EPC STORMWATER REVIEW COMMENTS IN ORANGE BOXES WITH BLACK TEXT

Grandview Reserve Phase 3 Preliminary Drainage Report

March 2024

GRANDVIEW RESERVE PHASE 3 EARLY GRADING & EROSION CONTROL PLAN

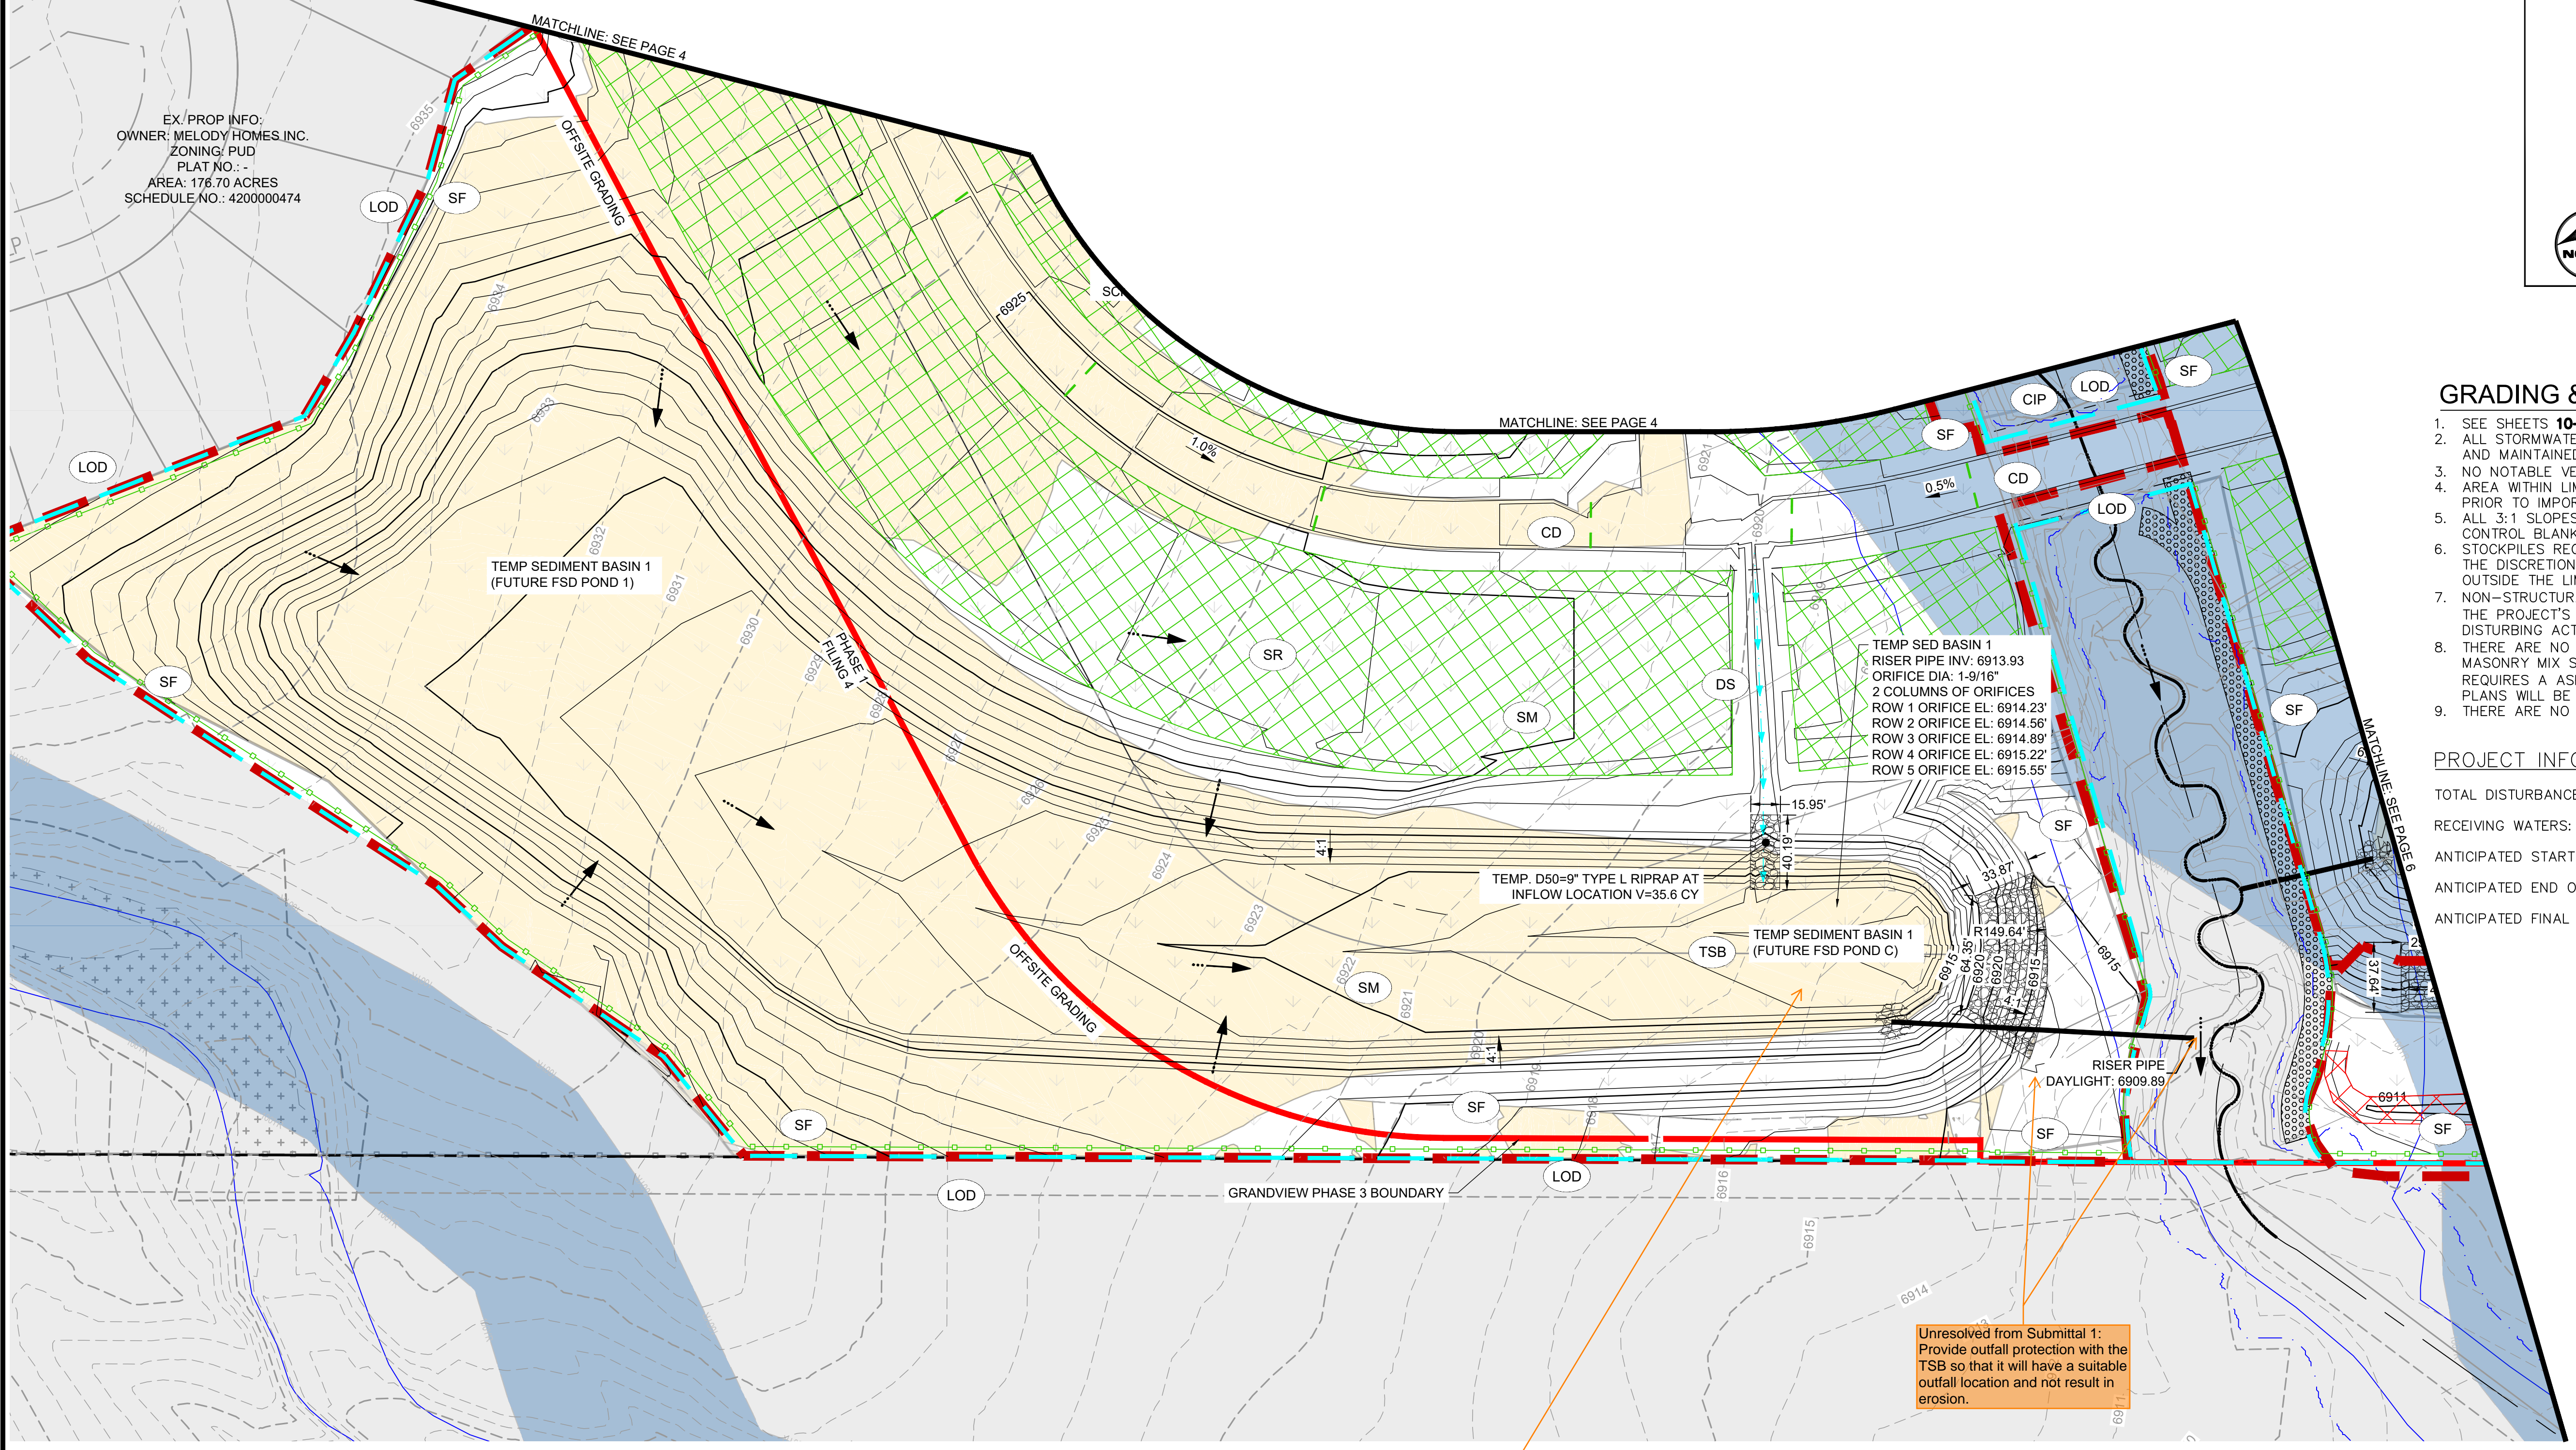
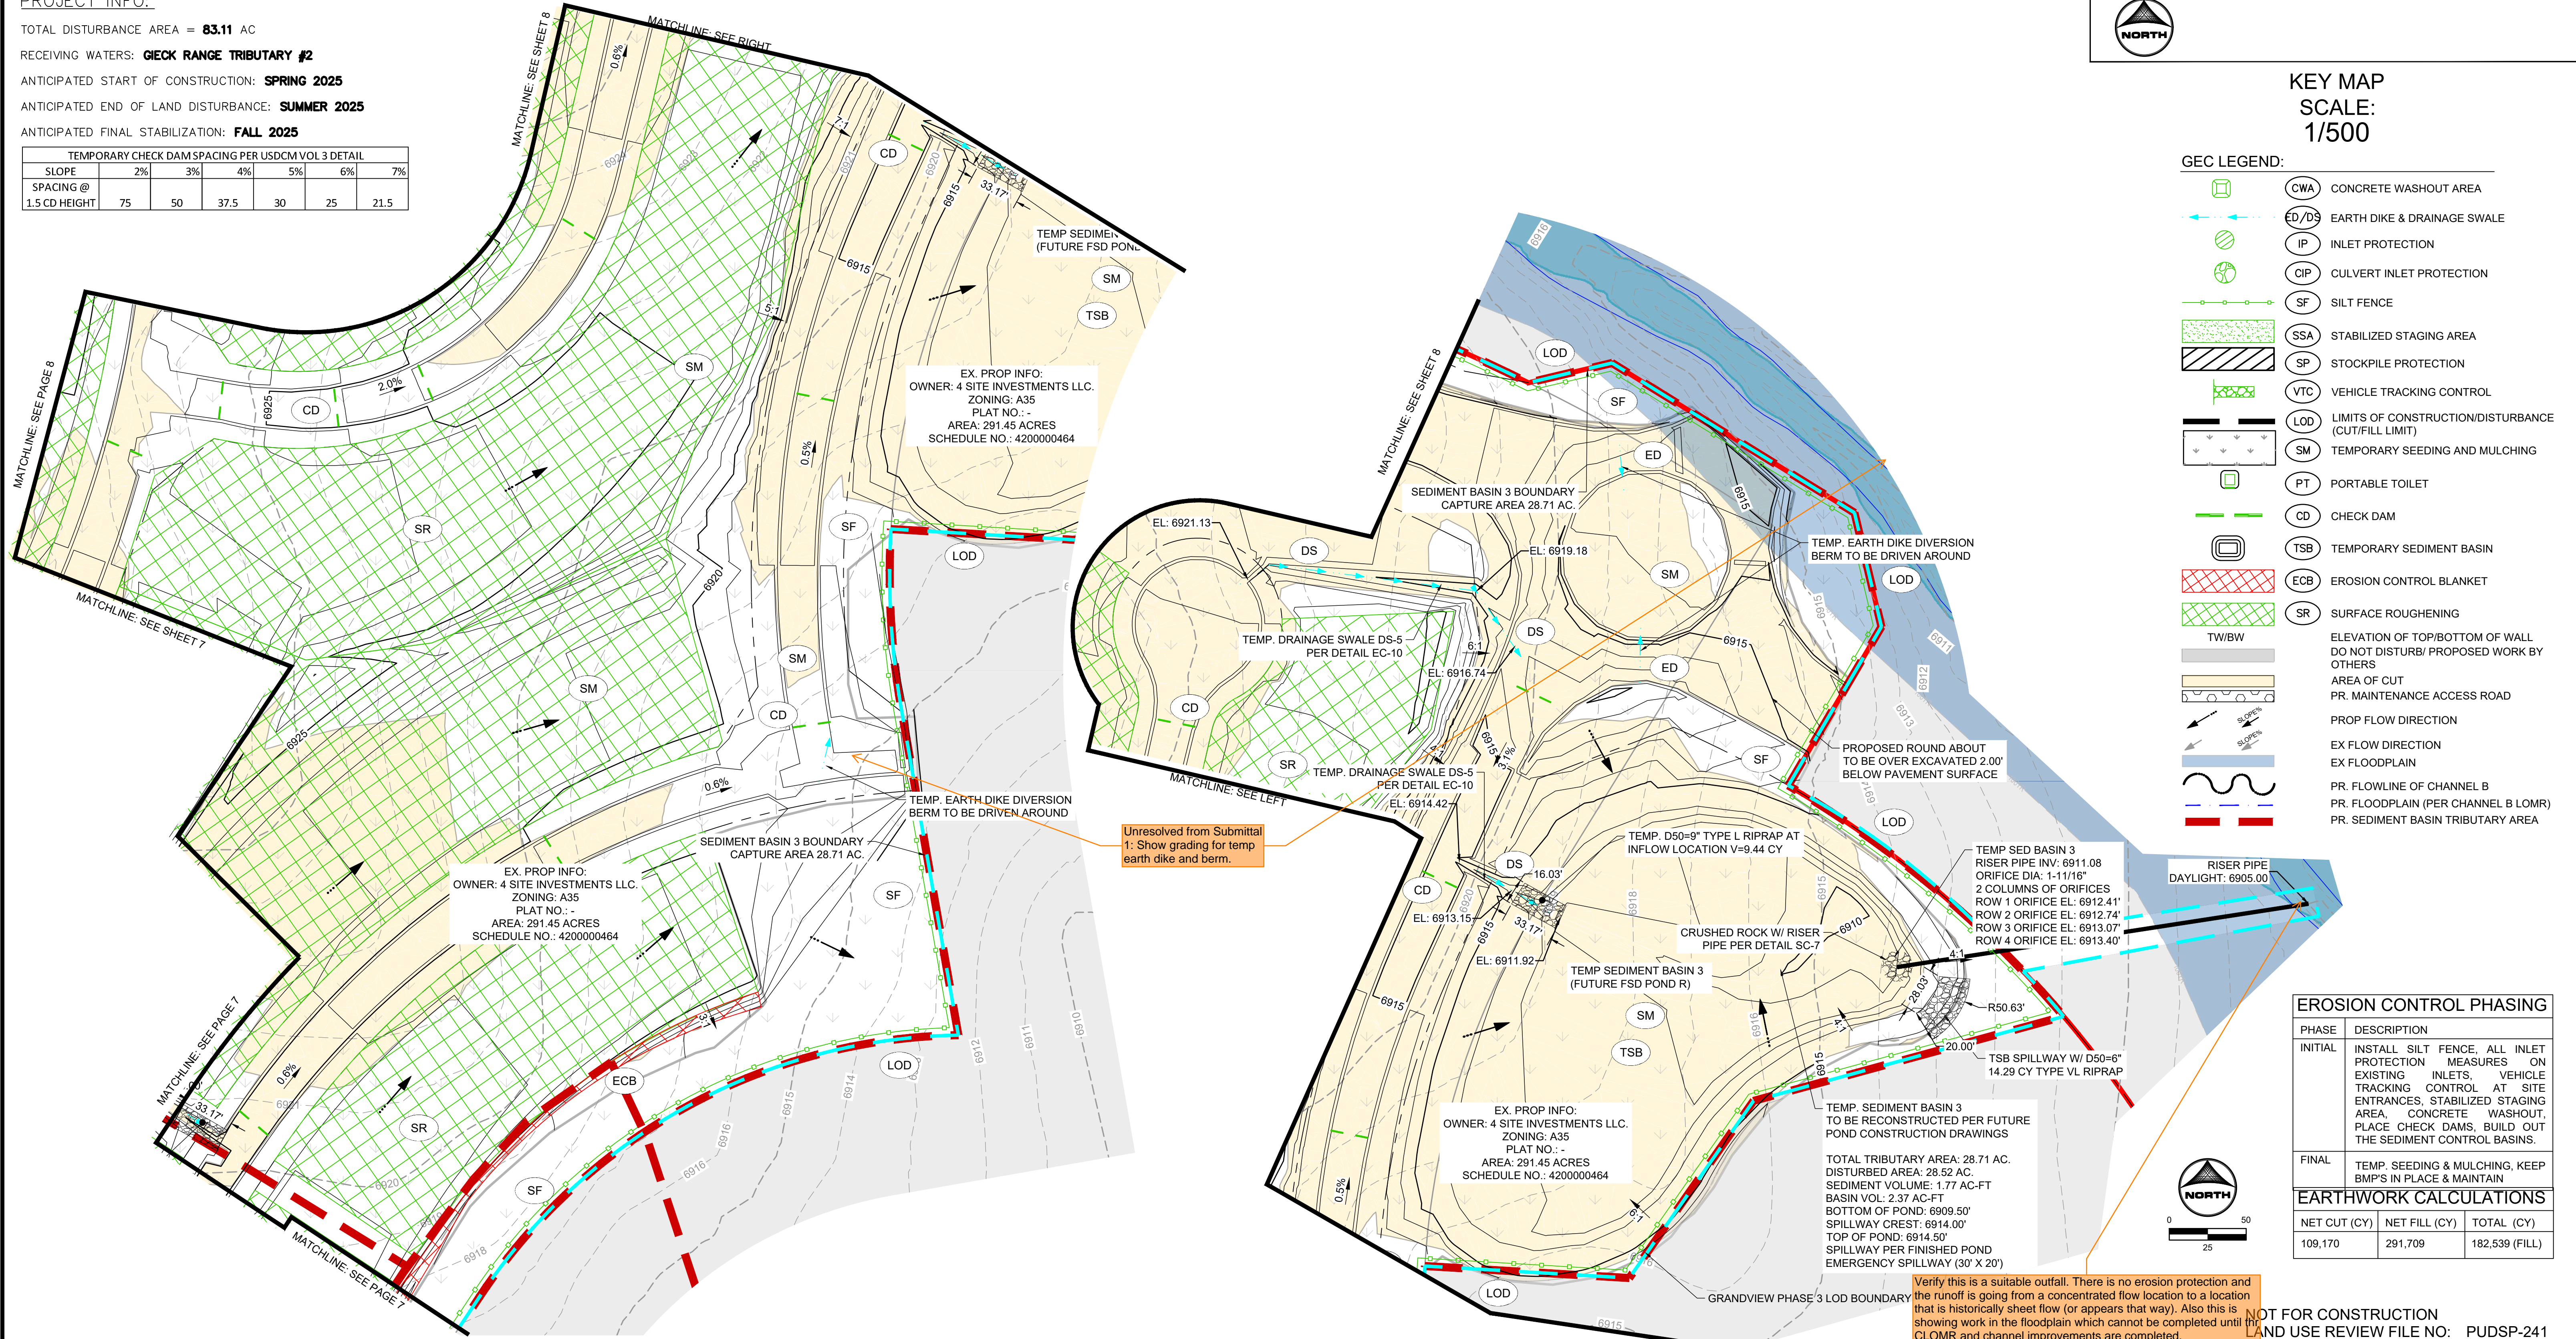
A final drainage report for the early grading will need to be submitted with the project.
